**SSD-66826207 – Fiveways Site including affordable in fill housing.
Amended Application - Arising from Responses to Submissions.
Closing date for submissions: 30 September 2024 @ 5:00pm**

Submission from: Wollstonecraft Precinct

Precinct objects to this amended application with reference to the amended Reports prepared by Gyde.com dated 12 September 2024:

Figure 2: Height of Roof Plant Equipment (Source: Turner & Marked-up by Gyde)

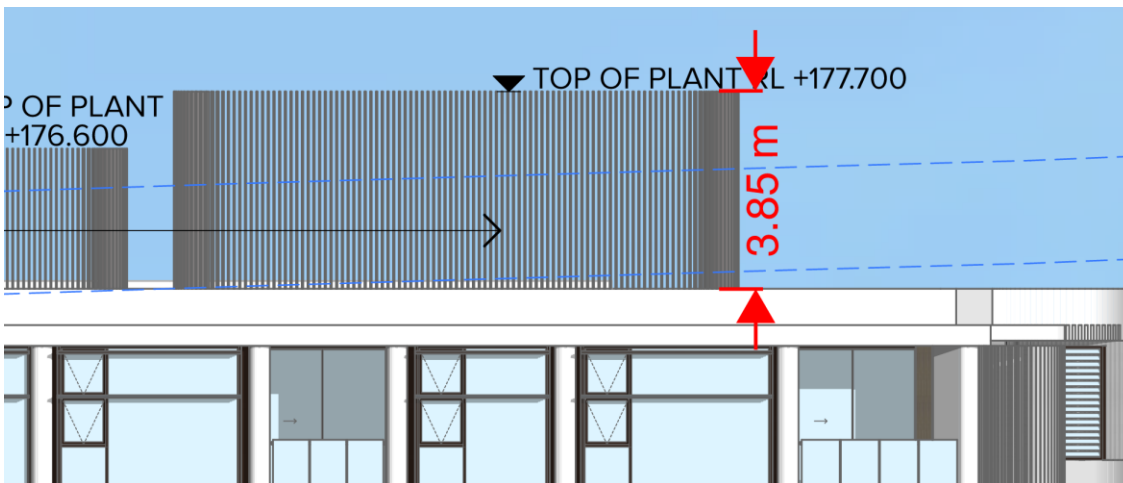
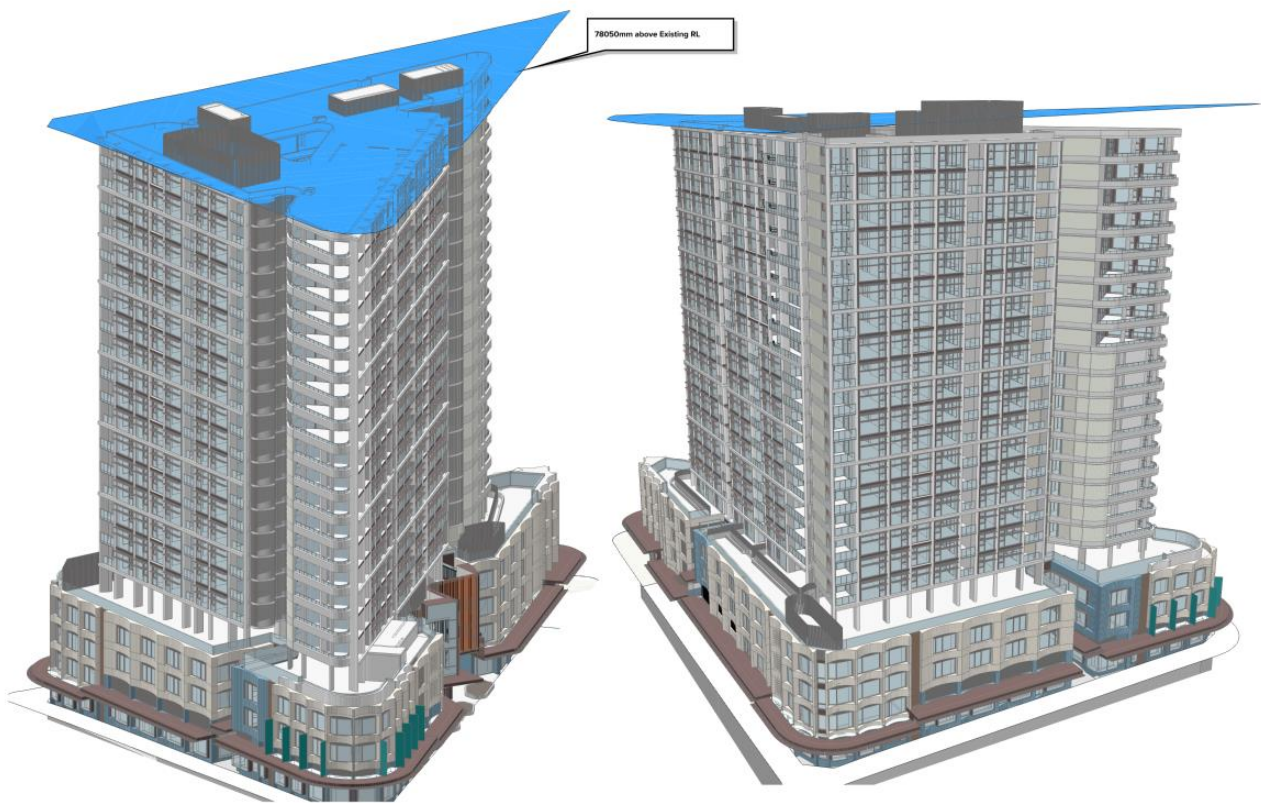
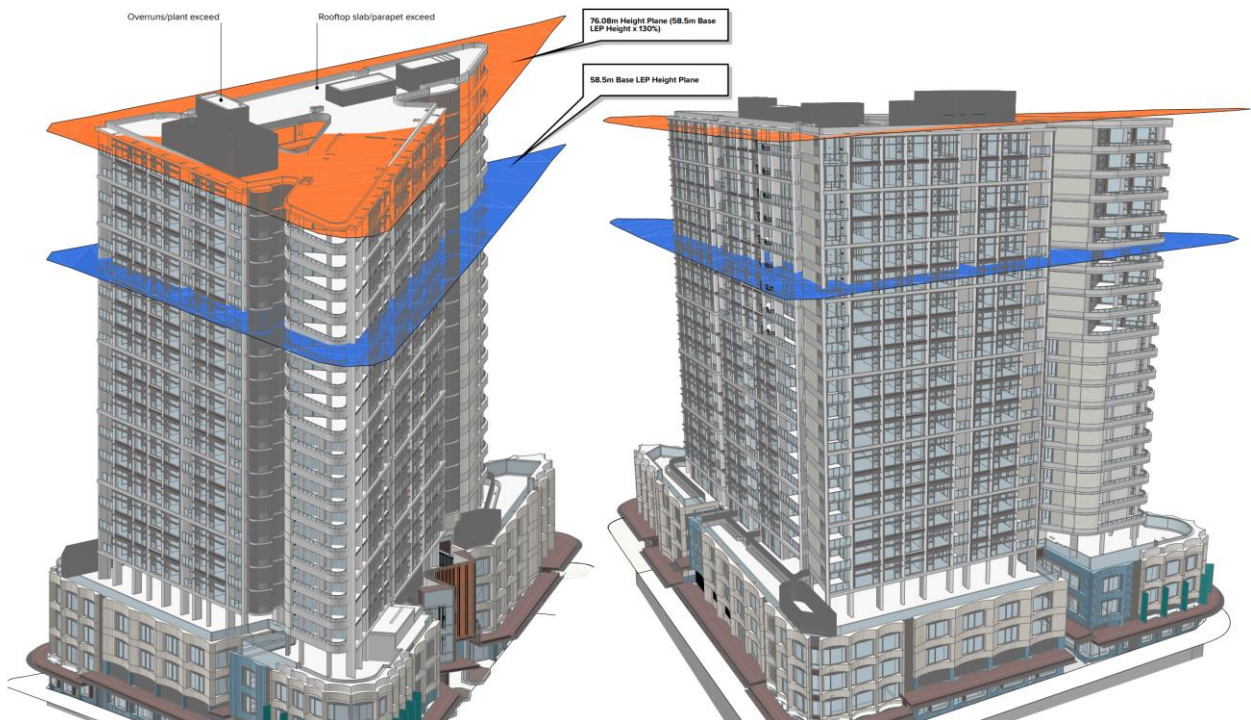
Building Height: Precinct objects to the Applicant's proposal to increase height above the maximum allowable under Clause 4.6 of the North Sydney LEP (2013)

Regarding this Clause 4.6 Variation request, the maximum height of the building (HOB) can be achieved by simply reducing the height of the Podium. The explanations and justifications offered by the Applicant to increase height purposely ignore the obvious solution. The Variation of Height Request is nothing more than a "try-on" and should be refused.

Height: The height of the building (HOB) has been dealt with in previous commentary above. No amount of argument can prove that the building height can not be controlled within the maximum height calculated using the formula of 1.3 times the approved height of 58.5m by simply reducing the height of the podium to that shown in the reference design submitted with the approved proposal. QED.
